TMS Designers Response Template

ROAD SAFETY AUDIT STAGE 1

Scheme Title	Phase 9, Heyford Park, Upper Heyford, Bicester
Client	Dorchester Living
TMS RSA Report Ref No:	TMS 14436
Road Safety Audit Team	RC/AS

DETAILS  
PHASE 9 S278 GENERAL ARRANGEMENT

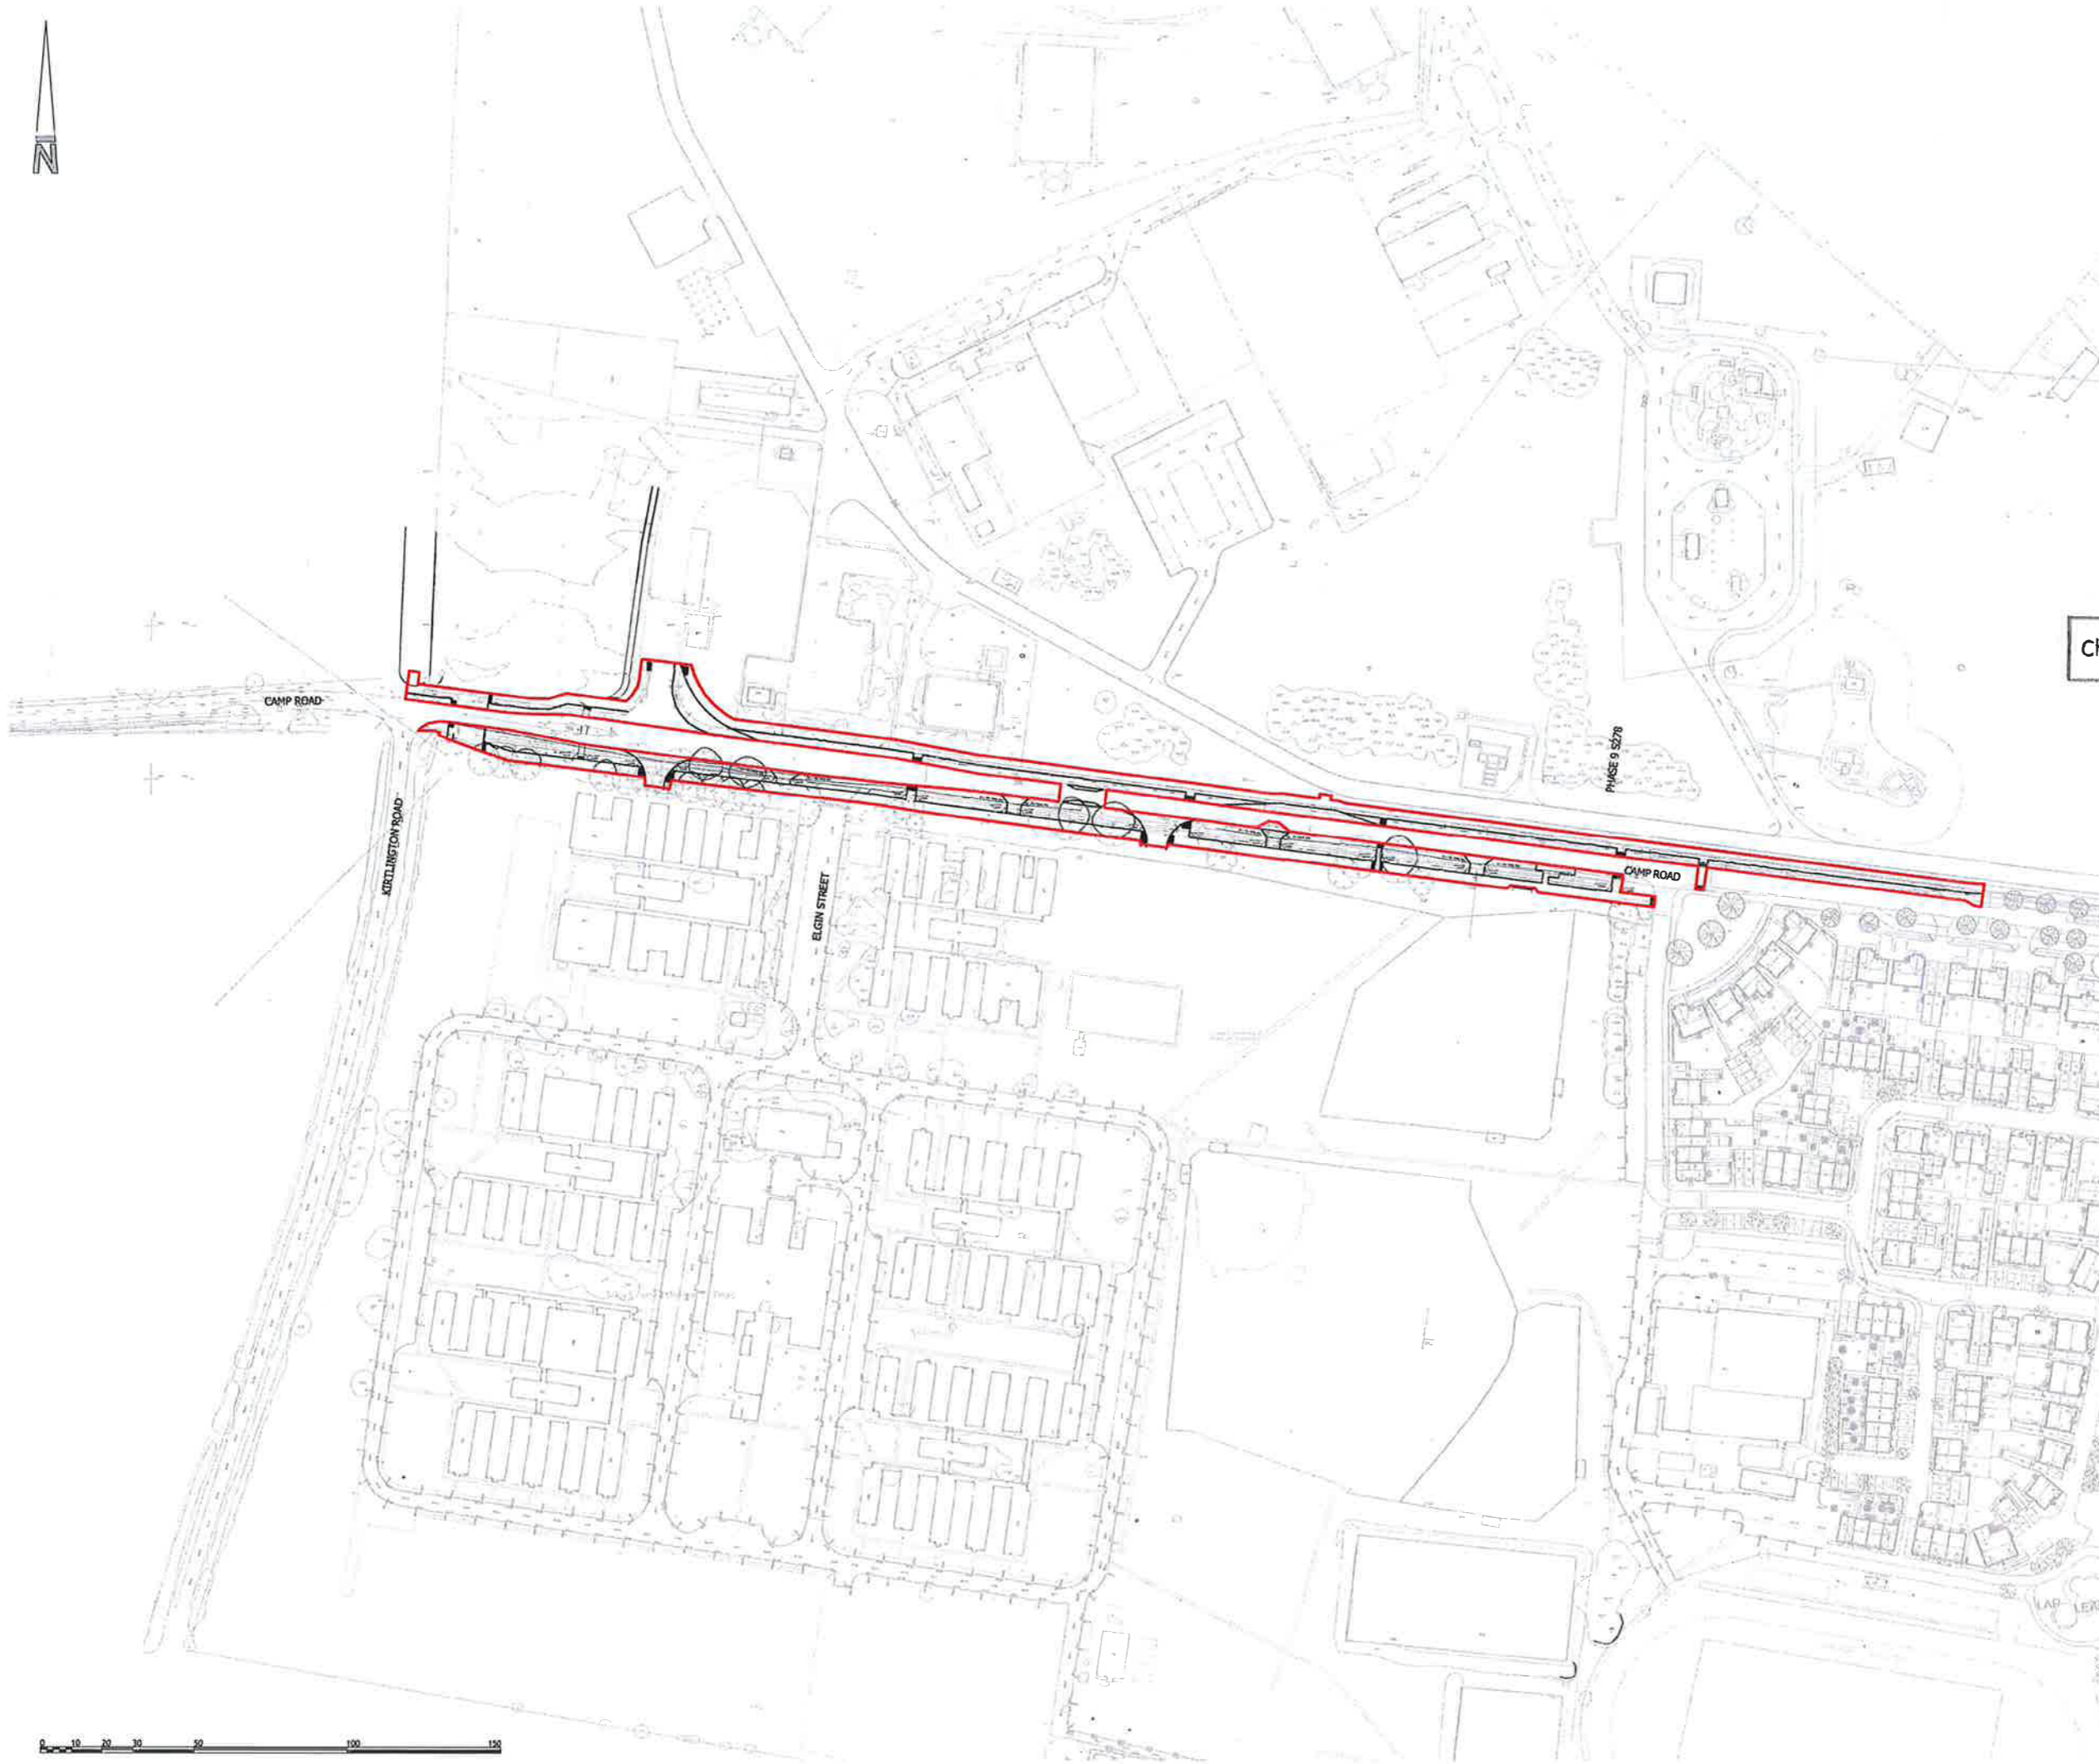
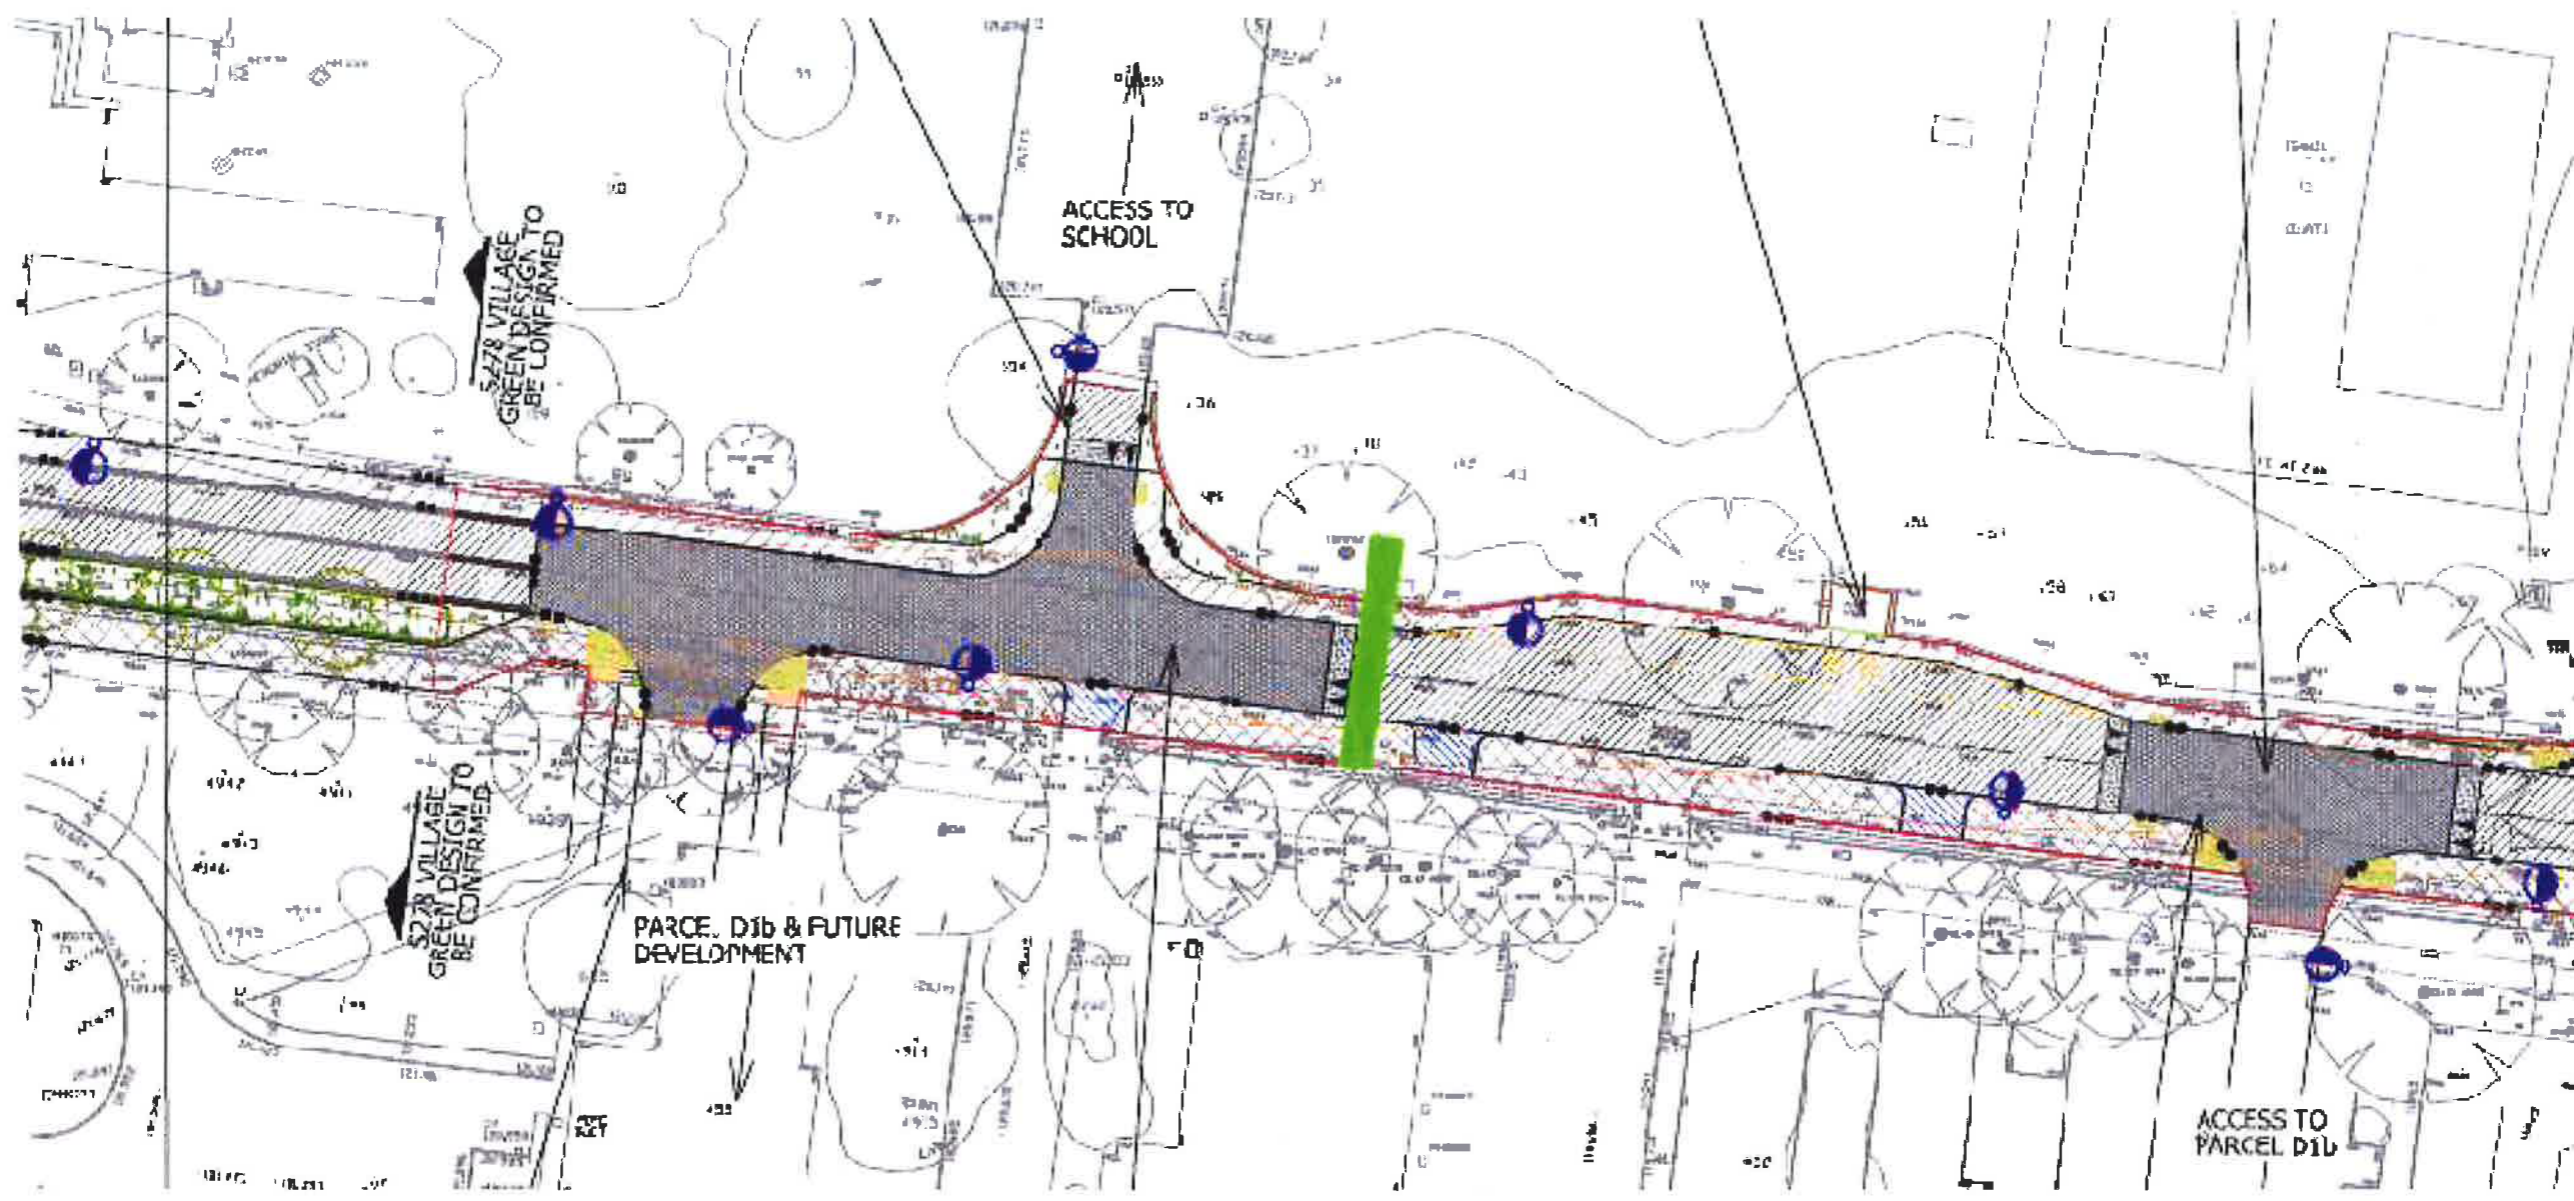
Problem Identified (Paragraph No)	Problem Accepted (YES/NO)	Recommendation Accepted (YES/NO)	Alternative measure (describe)
2.1	YES	YES	<p>10m RADII INTRODUCED TO TWO NEWLY PROPOSED ACCESS JUNCTIONS ONTO CAMP ROAD TO EASE TRACKING.</p> <p>GEOMETRY AMENDED ELSEWHERE WITHIN THE SITE TO PROVIDE SUFFICIENT MARGIN FOR ERROR ON CAMP ROAD AND IZZARD ROAD (TURNING RIGHT INTO THE DEVELOPMENT BOULEVARD ONLY – IZZARD ROAD JUNCTION IS EXISTING).</p> <p>TRACKING FROM IZZARD ROAD RUNS OVER THE HARD PAVED RUN-OVER AREA WHICH DOES NOT HAVE A KERB IN THIS LOCATION. KERBS ARE PROVIDED AROUND THE GRASSED CENTRAL ISLAND. FULL DETAILS TO BE AGREED AT S38 STAGE.</p> <p>SITING OF STREET FURNITURE TO BE DEALT WITH AT S38 STAGE BUT SHOULD BE CAREFULLY POSITIONED IN LINE WITH RSA COMMENTS.</p> <p>TRACKING RE-PRODUCED BASED ON VEHICLE SPEC AGREED WITH OCC ON 04.09.18.</p> <p>ADJUSTMENTS TO TRACKING HAS PULLED THE VEHICLE AWAY FROM DESIGNATED PARKING SPACES AS IDENTIFIED.</p>

2.2	YES	YES	<p>2m X 2m VISIBILITY PROVIDED TO ALL FOOTPATH, CYCLELINK & DRIVEWAY CROSSING POINTS. WE CONSIDERED PROVIDING A RAISED TABLE AND SIGNAGE TO OFFER PRIORITY TO PED/CYCLISTS BUT THERE WAS INSUFFICIENT REFUGE AREA FOR VEHICLES WHEN TURNING OFF CAMP ROAD FOR THIS TO WORK</p> <p>THEREFORE, IN ORDER TO PROVIDE ADEQUATE INTERVISIBILITY, THE FOLIAGE WILL BE TRIMMED BACK 5M FROM THE CROSSING POINT.</p>

2.3	YES	YES	<p>PEDESTRIAN CROSSING POINTS HAVE BEEN ADDED ACROSS THE SITE IN SEVERAL LOCATIONS. CROSSING POINTS HAVE BEEN MADE TARMAC AND DO NOT UTILISE RUMBLE STRIPS</p> <p>TACTILE PAVING WILL BE DETAILED AT THE S38 TECHNICAL DESIGN STAGE</p>

2.6	YES	NO	<p>THE PRIORITY JUNCTION TO THE NORTH OF CAMP ROAD WILL BE CLOSED OFF AS THE MAIN ACCESS TO THE BUSINESSES LOCATED ON THE FLYING FIELD AS PART OF THE LOCAL PLAN ALLOCATION AND ASSOCIATED PLANNING APPLICATIONS. THIS JUNCTION IN THE FUTURE WILL ONLY ACCESS THE NURSERY.</p> <p>THE CLOSURE OF ACCESS TO THE BUSINESSES IN THE NORTH WILL SIGNIFICANTLY REDUCE THE AMOUNT OF VEHICLE MOVEMENTS (INCLUDING HGVS) AT THIS JUNCTION WHICH WILL REDUCE THE LIKELIHOOD OF CONFLICTS.</p> <p>THE JUNCTION LAYOUT WILL ALSO BE REVIEWED AT THE S278 STAGE TO UNDERSTAND IF THE EXISTING GHOST ISLAND FOR RIGHT TURNS INTO THE JUNCTION TO THE NORTH CAN BE AMENDED TO PROVIDE AN ISLAND FOR RIGHT TURNERS TO BOTH THE NORTH AND SOUTH.</p>

2.7	YES	YES	1M LEVEL VERGE PROVIDED
